From: [Dale, Louise Miss \(DIO Estates-SafegdgMgr2\)](#)
To: [Gregory, Michele](#)
Subject: 20190610: A303 Sparkford to Ilchester - Request for further information
Date: 10 June 2019 11:47:45
Attachments: [20190610 10044194 Yeovilton PINS Request FINFO-Final Draft.pdf](#)

Your Reference: TR010036
Our Reference: 10044194

Application by Highways England for an Order granting Development Consent

Examining Authority's request for further information

Location

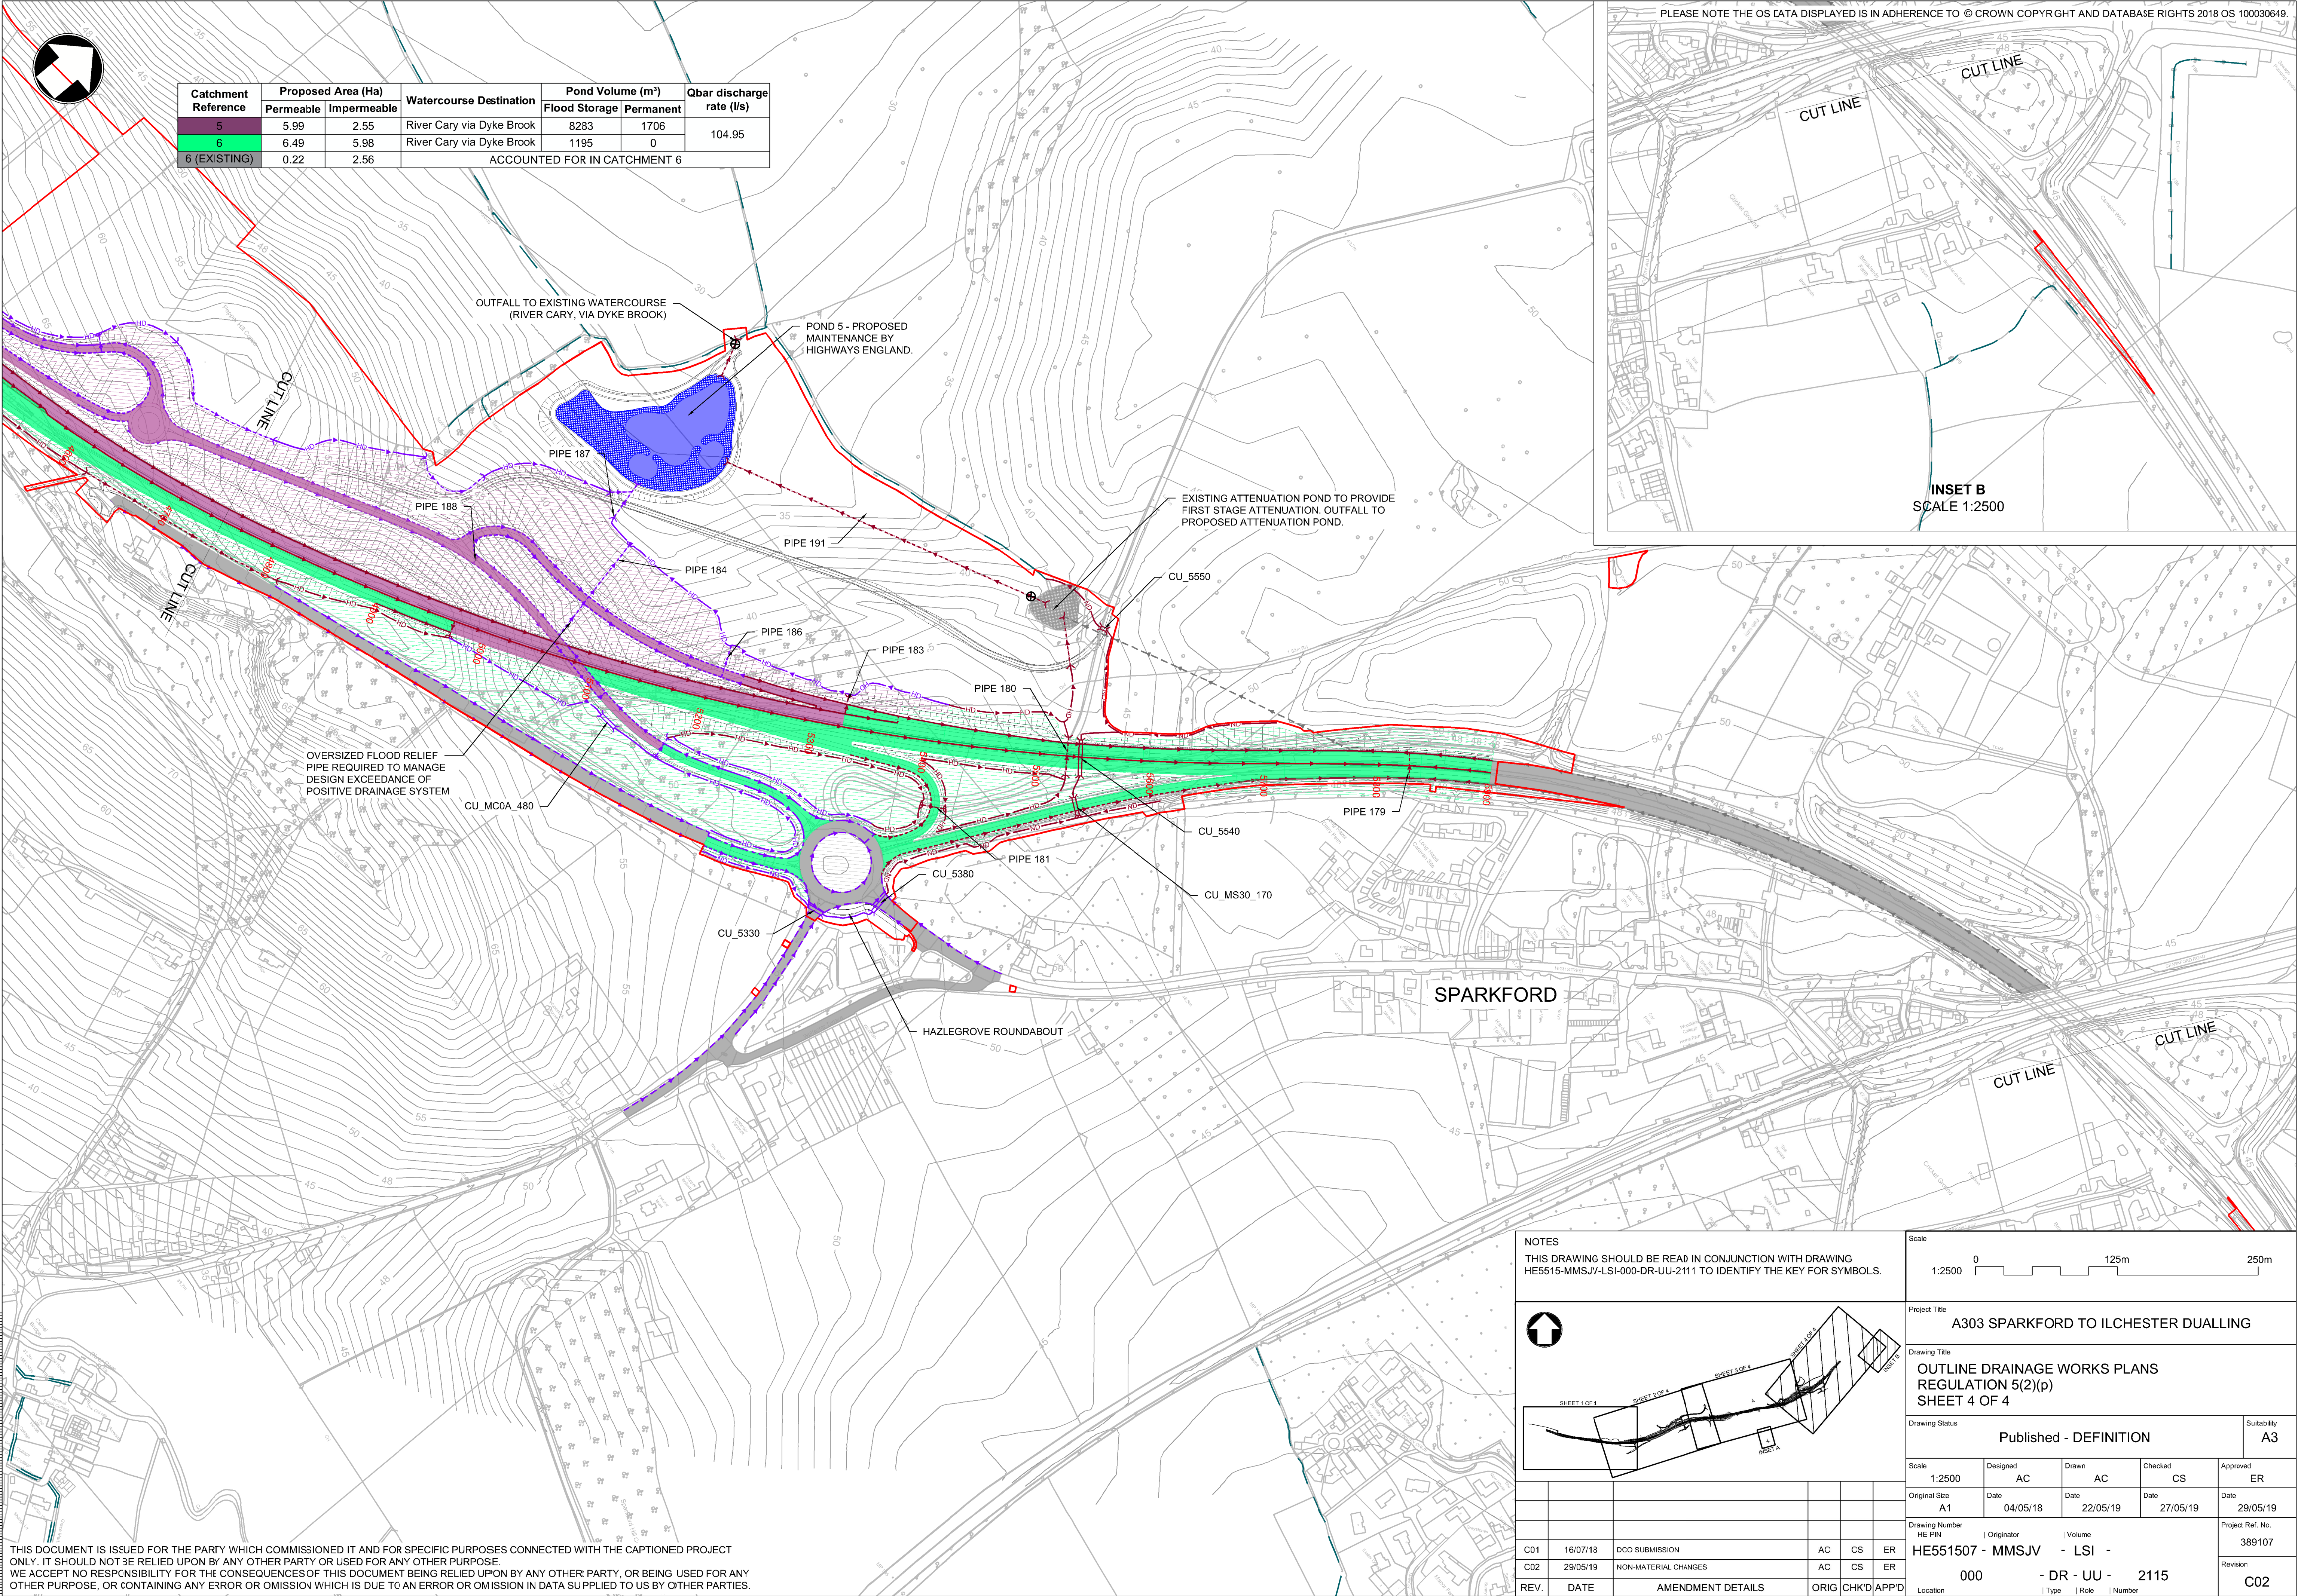
At present the Ministry of Defence (MOD) has statutory birdstrike safeguarding concerns regarding the proposed ponds. In particular ponds 1-3 as these water bodies are located beneath the approach into Runway 22 and the take off climb for Runway 04. Also, the recovery and departures routes from RNAS Yeovilton to Merryfield Airfield fly over pond 1 at 500ft.

The MOD concerns are based on the creation of open water bodies at these locations having the potential to increase the attractiveness of the site to existing flocking bird species such as gulls, starlings etc. These species are deemed hazardous to aircraft safety especially when in critical stages of flight.

DIO Safeguarding met with Highways England on the 9th May and identified our preferred option would be for the ponds to be predominantly dry and for the basins to dry down within 72hours following a 1 in 100 year storm event.

If Highways England could not achieve this, the MOD recommended how bird attractants could be *designed out* using the following principles:

Pond bank sides to be as steep as possible

- No visible area of open water, meaning the ponds are to be densely planted with marginal vegetation common reed (*Phragmites Australis* is the MOD's preferred option). This species of reed provides continuous year-round cover as it does not die back in Winter.

- A Bird Hazard Management Plan (BHMP) should be established and implemented for the maintenance of the reeds to prevent a starling roost. If a starling roost establishes, Highways England will disperse birds via appropriate licensed means. The BHMP should also cover the construction phase. Whilst works are being carried out the turning of soil provides exploitable feeding opportunities for flocking bird species, and water can gather in holes and voids during works. The management plan should include a commitment for Highways England to disperse bird species hazardous to aircraft safety.

On reviewing the information available the MOD's ornithological advisors determined that provided the ponds are designed in accordance with the recommendations outlined above, the size of the ponds and depth are satisfactory. They are not large enough to host a gull roost which would be a major birdstrike concern to the MOD.
